CITY OF ALBUQUERQUE

August 22, 2012

**Re: Plastic Machine Shop Addition, 2601 Baylor Drive SE,
Traffic Circulation Layout
Architect's Stamp dated 08-06-12 (M16-D037)**

C3 ADA Curb Ramp
1/4" = 1'-0"

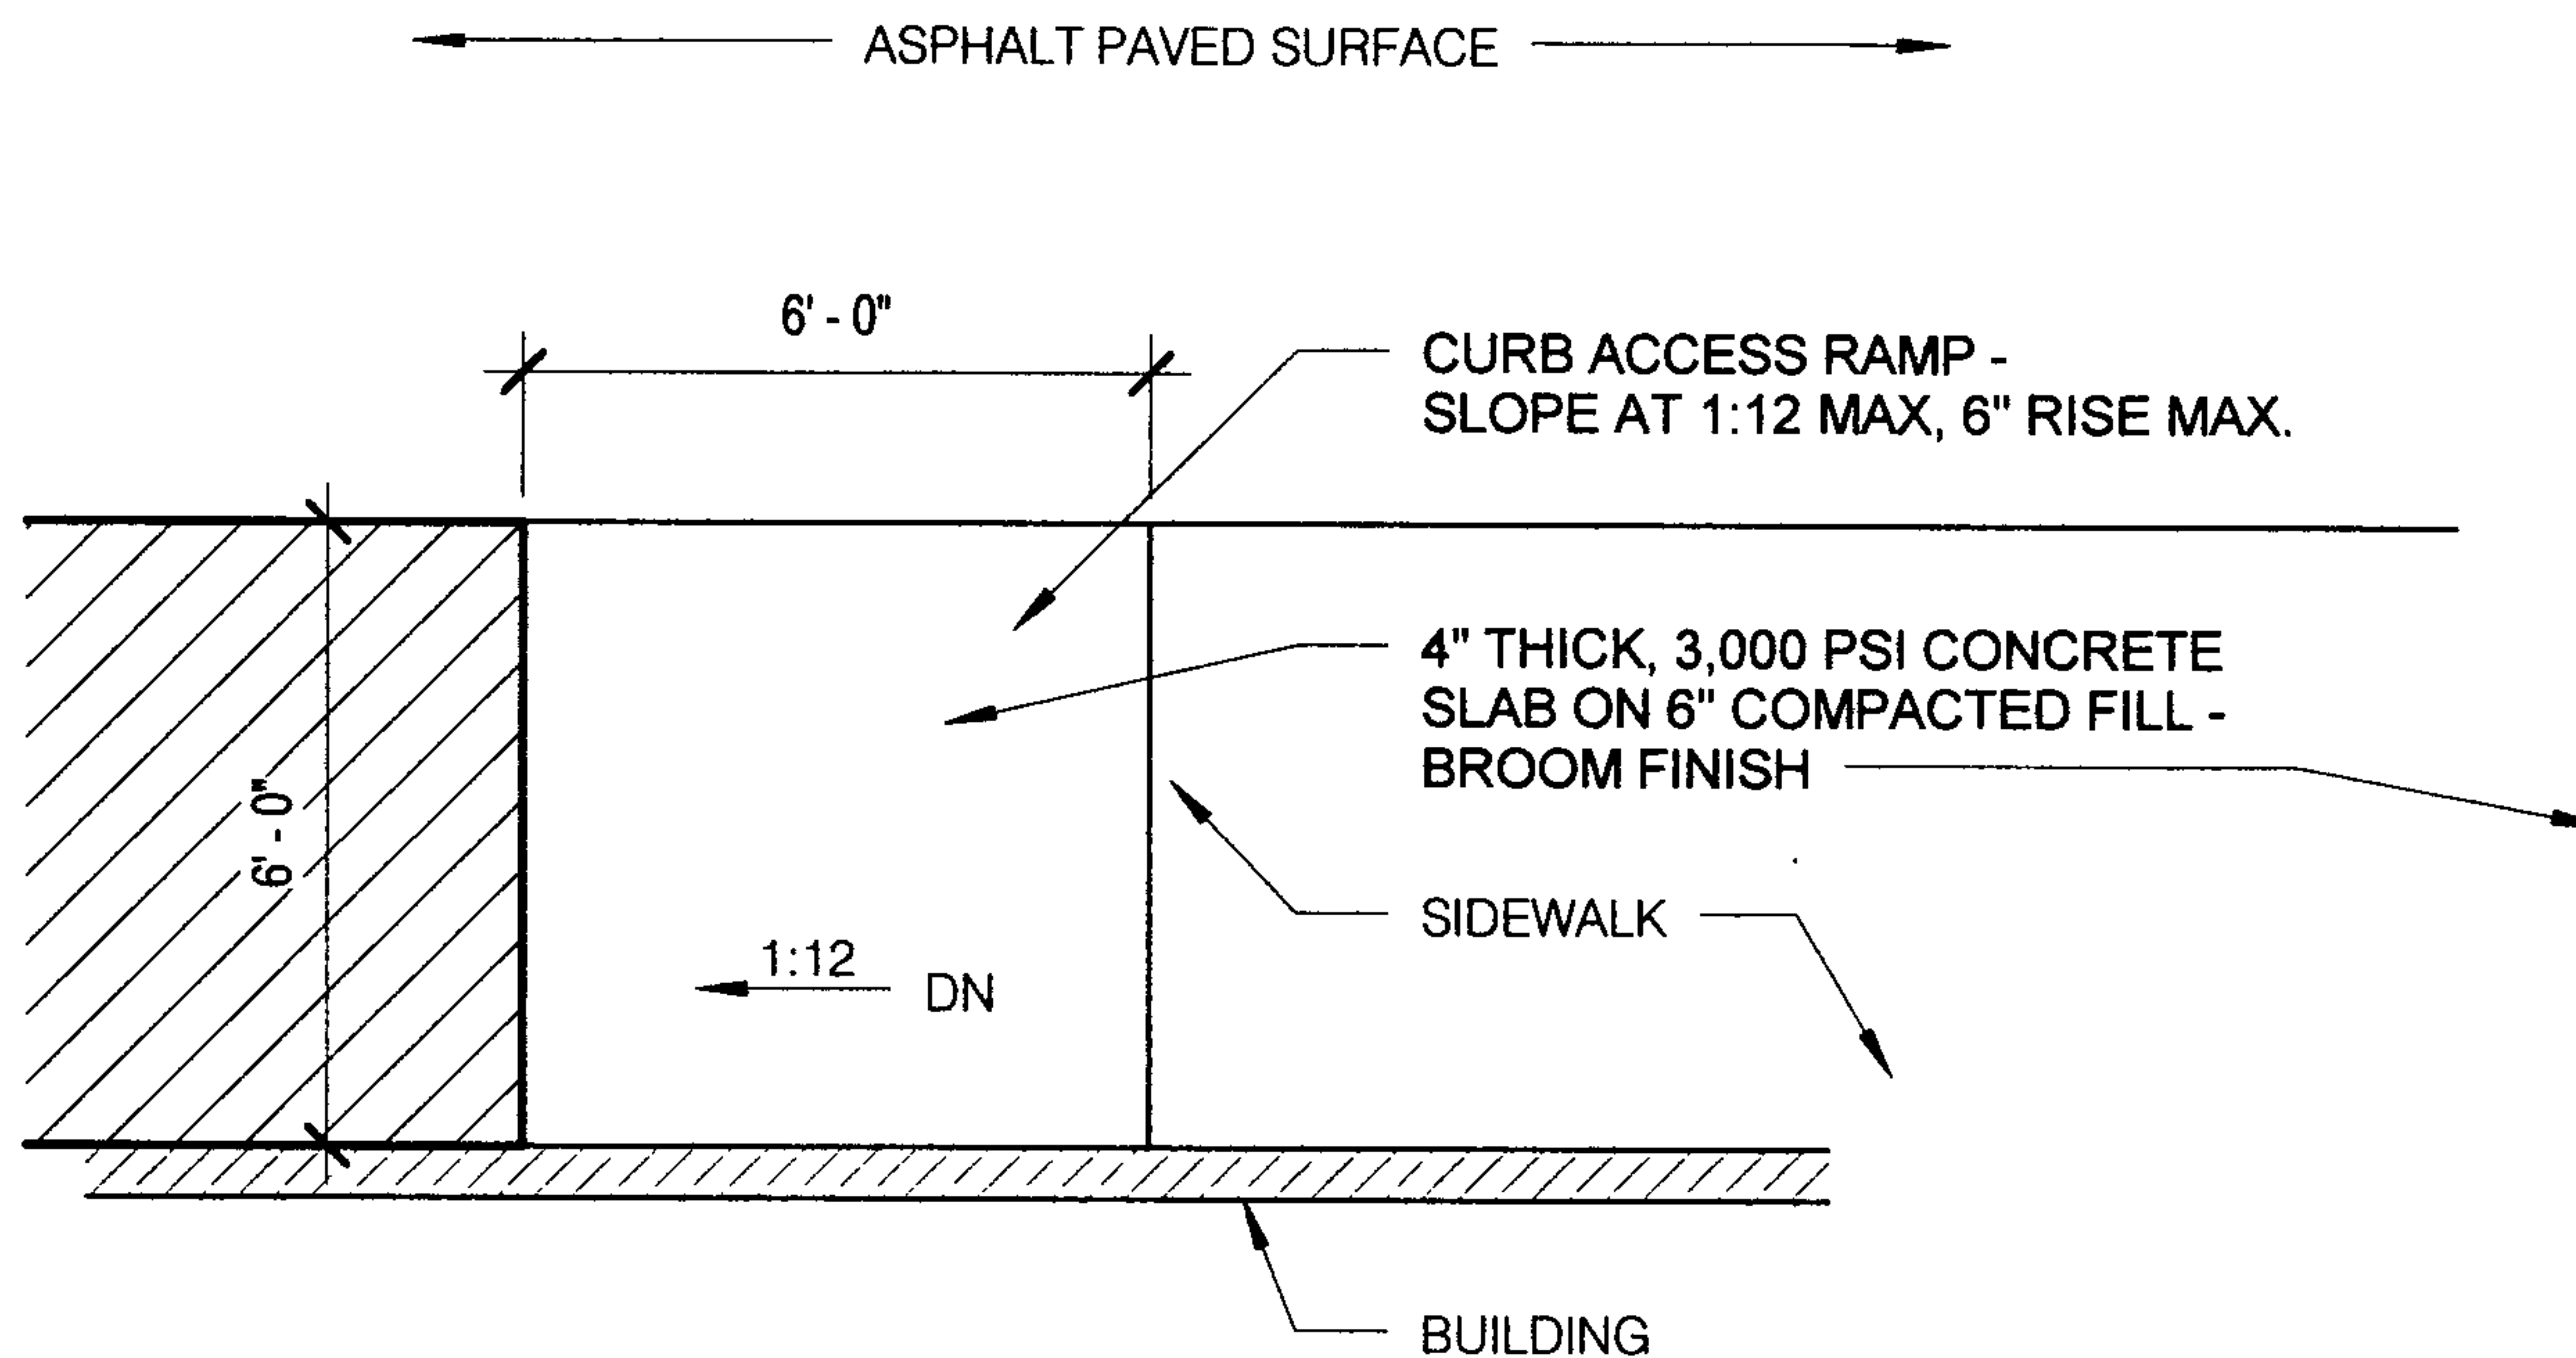
1. The proposed ramp must not be located within City right of way. Please revise.
2. The existing entrance appears to be a curb cut (City of Albuquerque Standard 2425). Curb cuts do not have ramps, they have ADA pathways.
3. For passenger vehicles, the minimum end island radius is 15 feet.
4. Show the 6-foot wide, ADA accessible, pedestrian pathway from the ADA parking to the building. Show all ramps and provide details.
5. The existing loading dock appears to interfere with traffic circulation.
6. Show the 6-foot wide, ADA accessible, pedestrian pathway from the roadway to the building.
7. The legal description provided does not match City GIS records. Per our records, this site consists of three lots: 13A, 1D3, and 1D4, Block 1, of the Airport Industrial Park. Has this site recently been replatted?
